Our ref: DOC21/673941
Senders ref: SSD-11429726

Subject: Exhibition – Eden Street, Arncliffe Mixed Used Redevelopment (SSD-11429726)

Thank you for your email received 29 July 2021 requesting comments on the above proposal. Environment, Energy and Science Group (EES) has the following comments.

RFI RESPONSE:
CLARIFICATION TO
TREE RETAINED,
REMOVED AND
RELOCATED

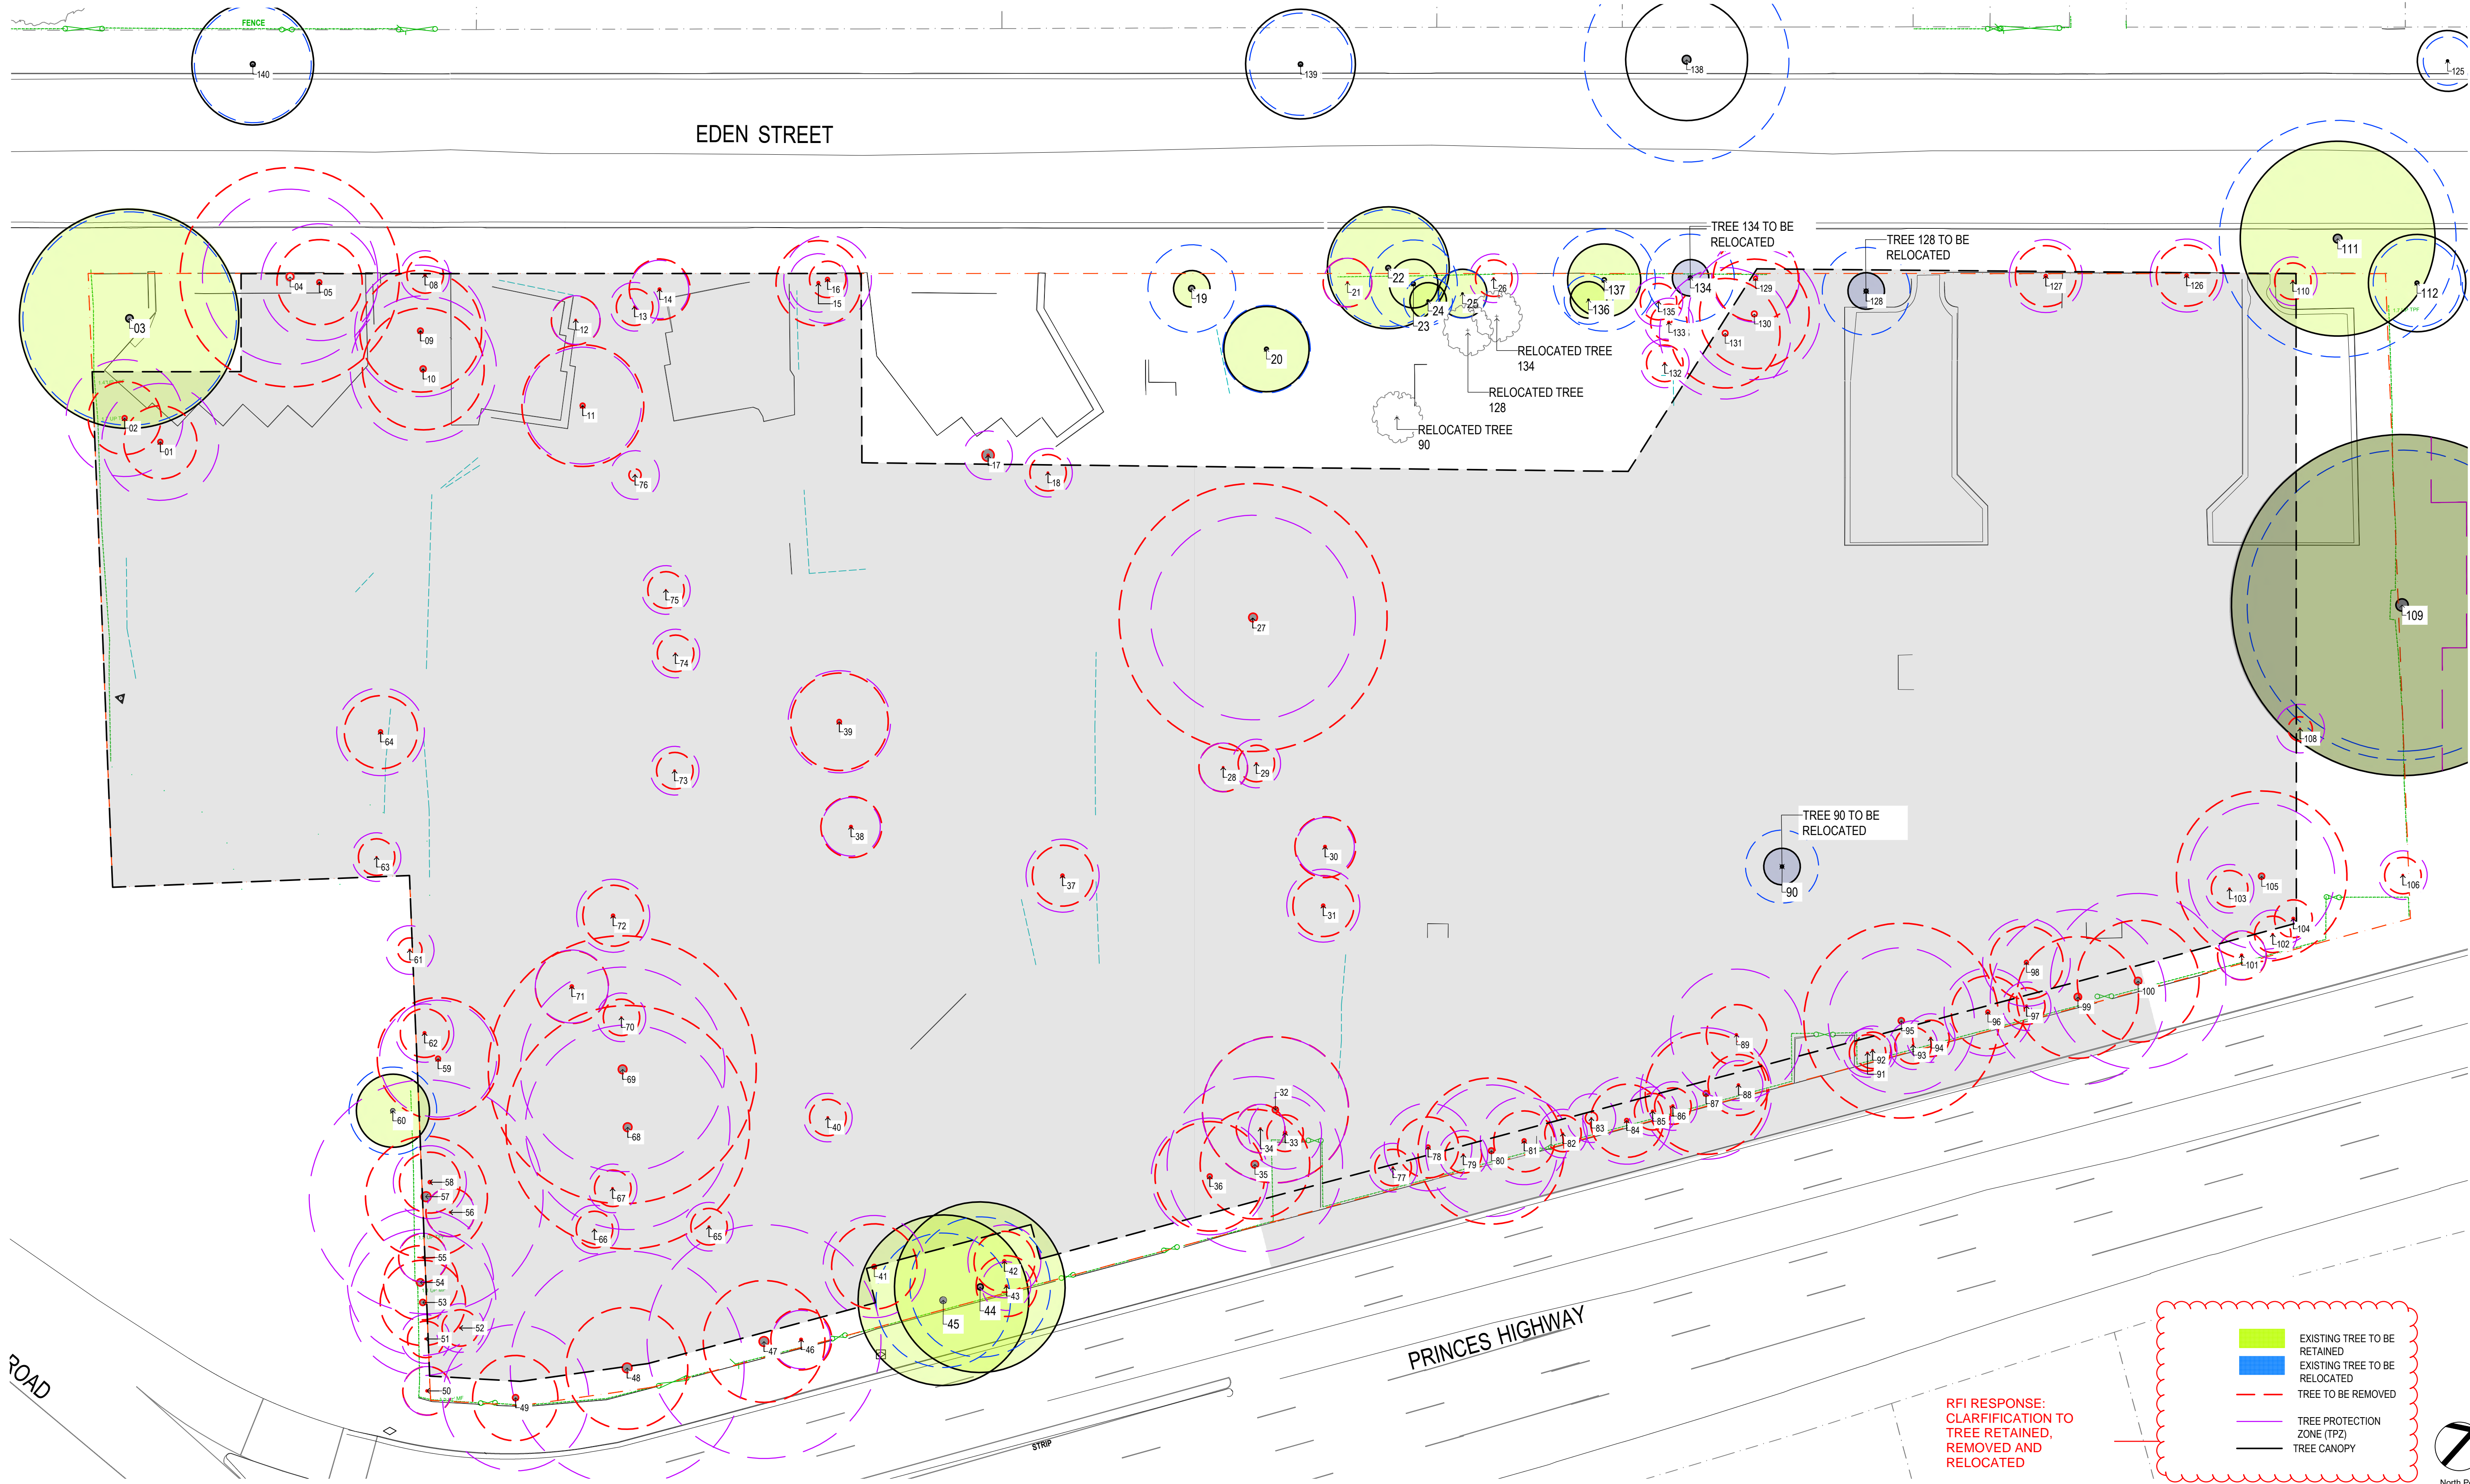
The Arboricultural Impact Appraisal and Method statement prepared by Naturally Trees dated 16 November 2020 (the arborist report) provides recommendations for the retention and protection of two significant trees including one *Eucalyptus pilularis* (tree 109 located within the adjoining property at 20-24 Eden Street) and one *Lophostemon confertus* (tree 111 located within the Eden Street road reserve). Tree 109 was specifically noted for retention in the BDAR Waiver Assessment prepared by Cumberland Ecology dated 7 January 2021. Architectural plans show works are proposed within the tree protection zone of these trees which is not consistent with the recommendations of the arborist report. To ensure the protection and retention of these trees the recommendations contained within the arborist report are to be implemented. In particular, for tree 109, the arborist report notes that existing levels between the tree and the exploratory trench (as detailed in the report), must remain unaltered and that there is to be no services or built structures placed within this critical zone.

Design changes within the tree protection zone of these trees will be required to comply with the recommendations of the arborist report and ensure the retention and protection of trees 109 and 111.
